REPORT UPDATE

BR/324/07/

Ground floor utility & WC extension &
second floor bedroom, bathroom
extension

19a Scott Street
Bognor Regis

ELEVATIONS AS PROPOSED	
Scale	1:100 @ A3
Date	05-10-07
Drawn By	ACB
Checked	KEH
Drawing Number	3612 / 13

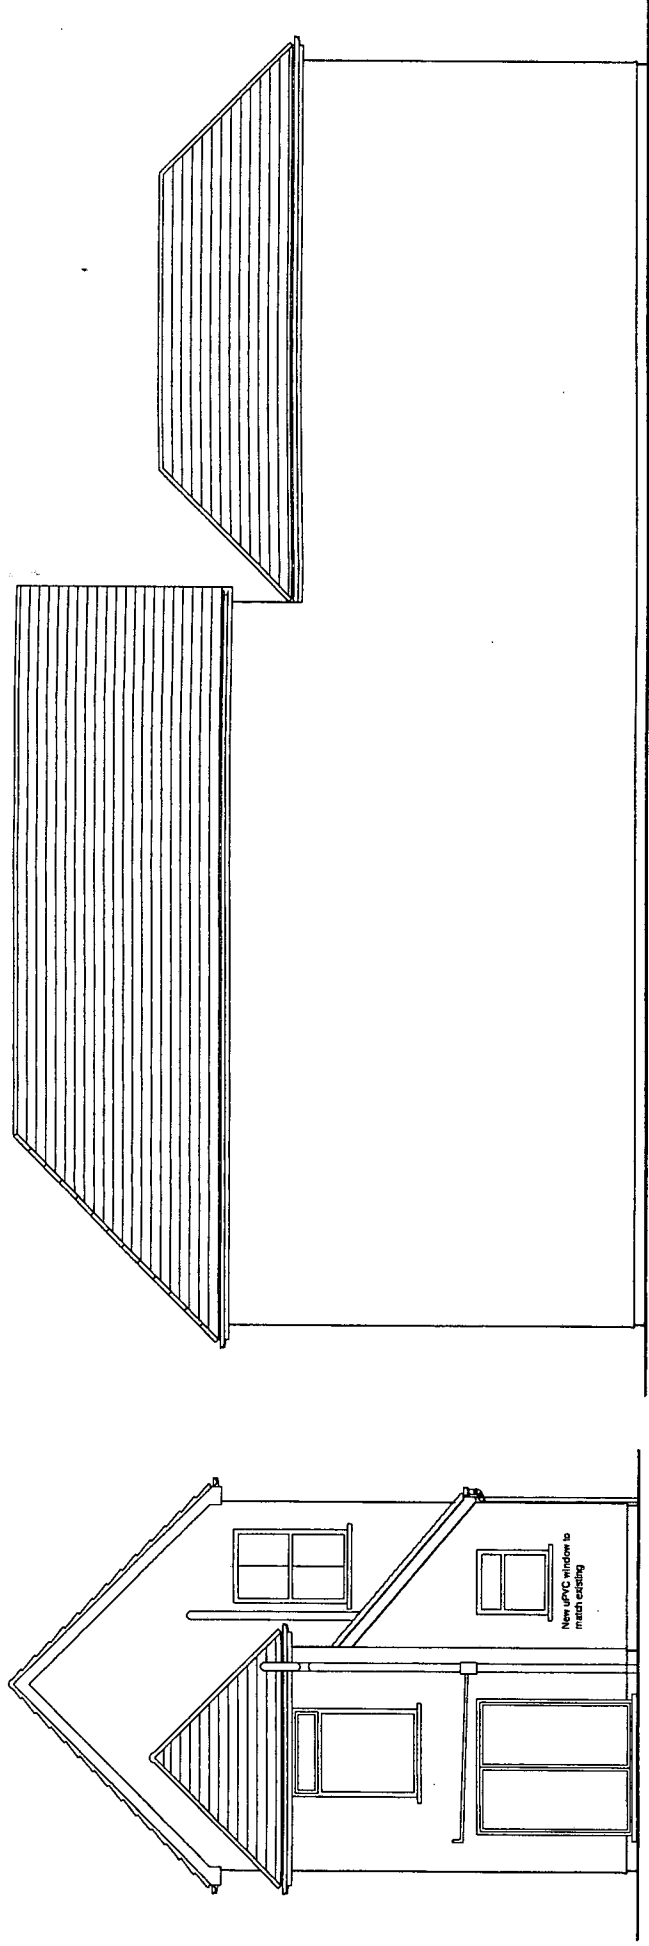
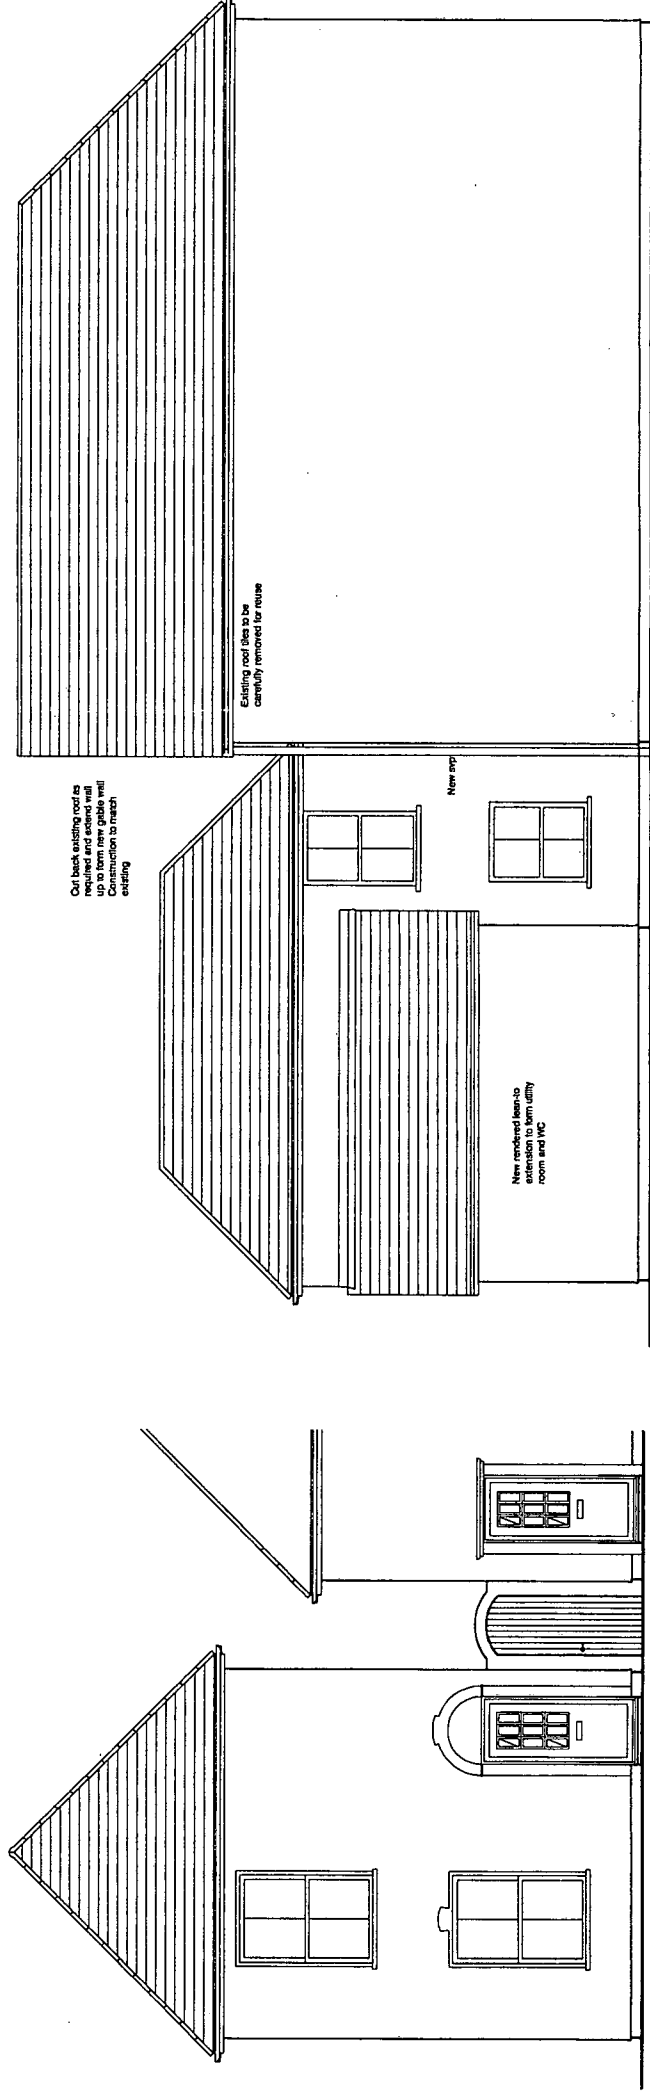
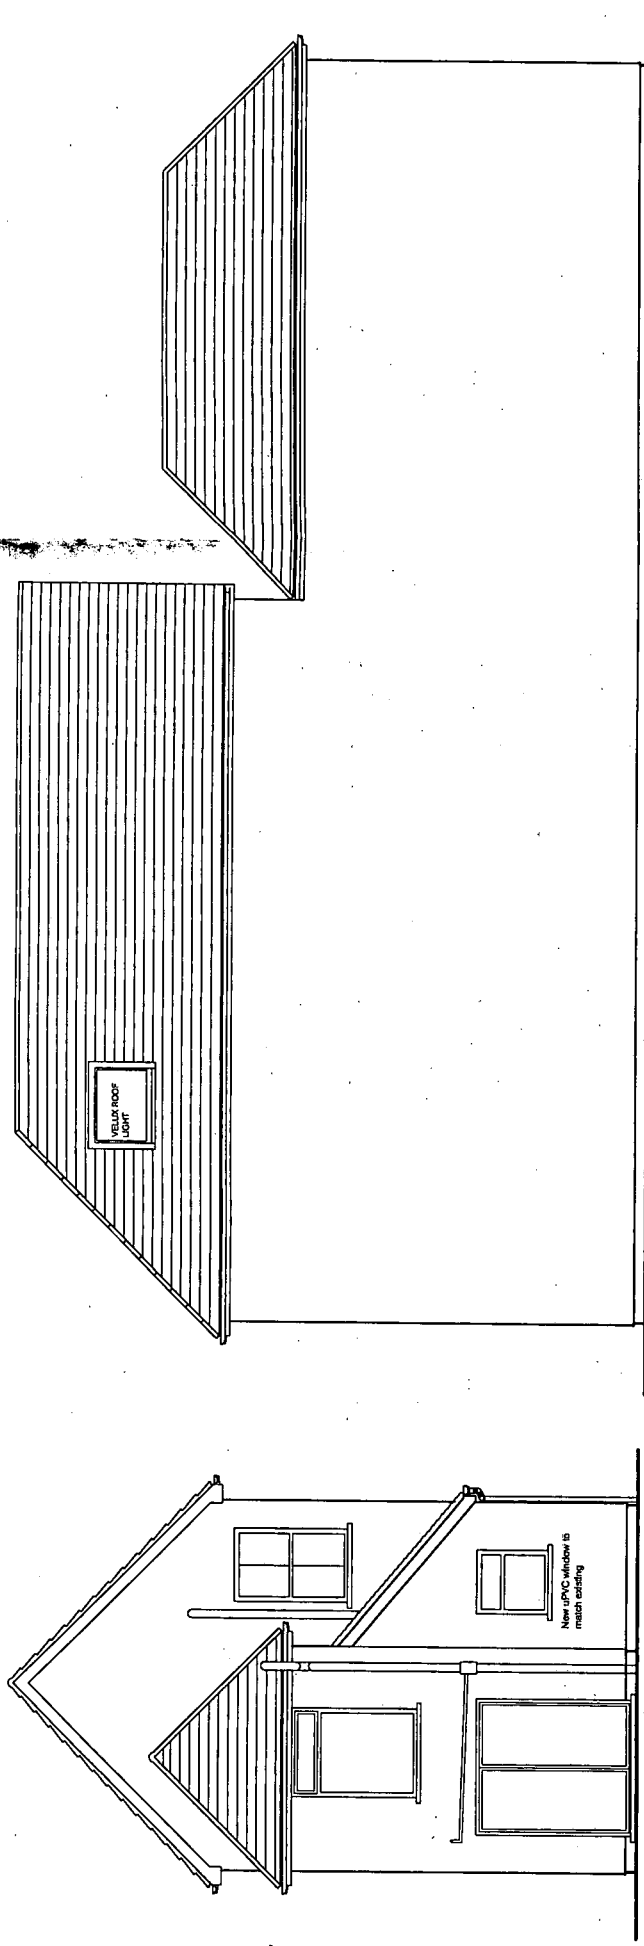
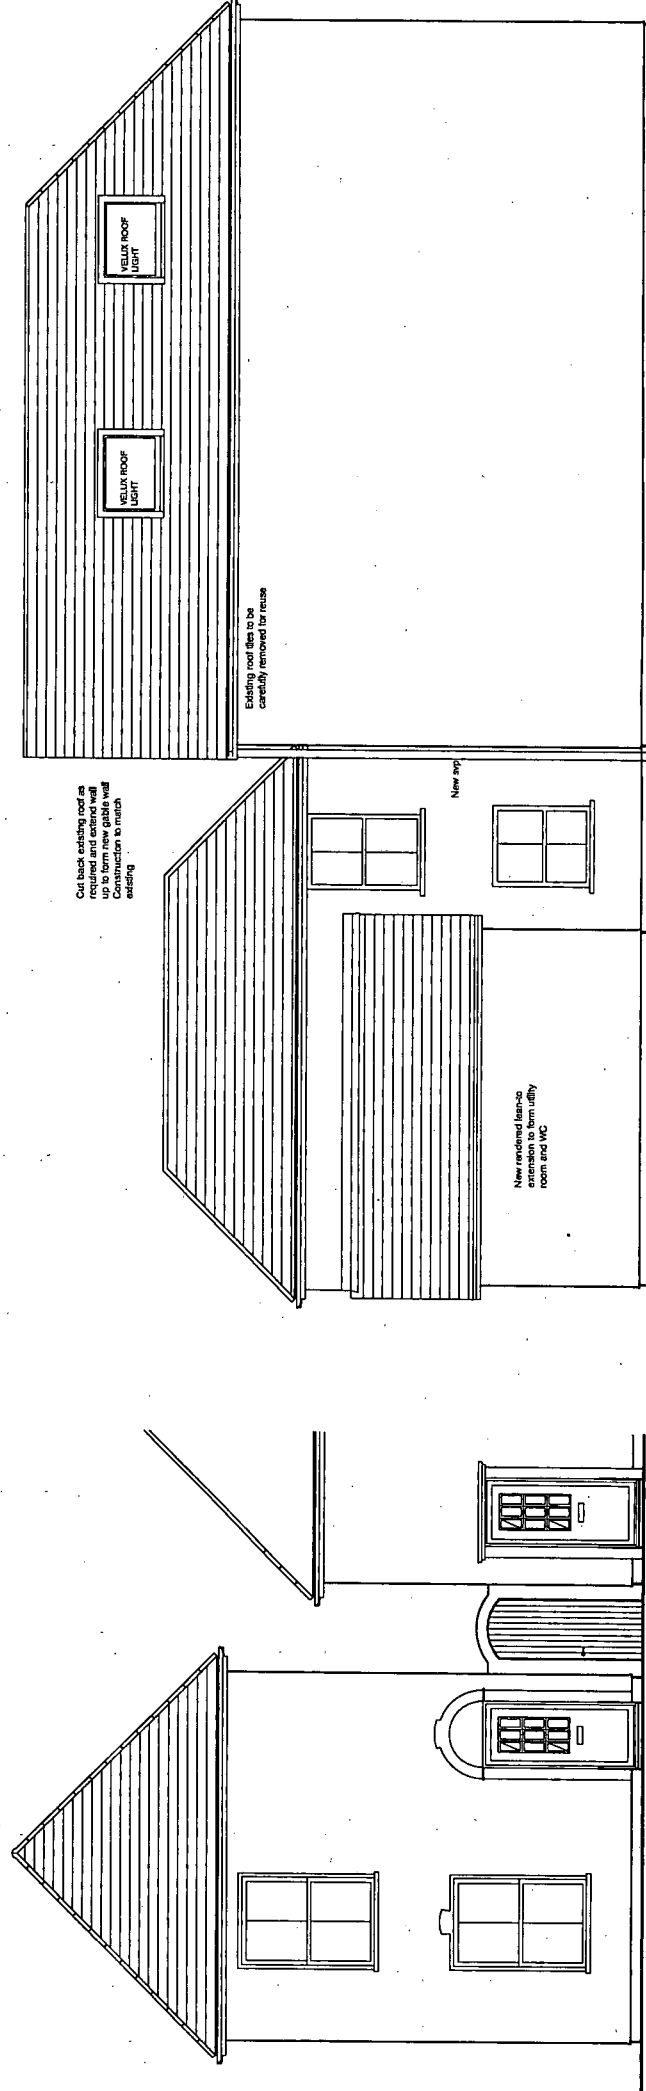
Application No :	BR/324/07/
Agenda Page No :	154-158
Reason for the Update - Amended plans and Recommendation sheet Amended plans have been submitted, which detail the 2 no. roof lights proposed to the west roof slope.	
Officer Comment: Condition 3 relating to amended plans has been added to the attached recommendation sheet.	
Note: Changes to recommendations, conditions and/or reasons for approval will always be accompanied by a new replacement recommendation sheet.

- 3 This permission relates to the plans as submitted and amended by substitutedrawing number 3612/13 dated 15th January 2007.
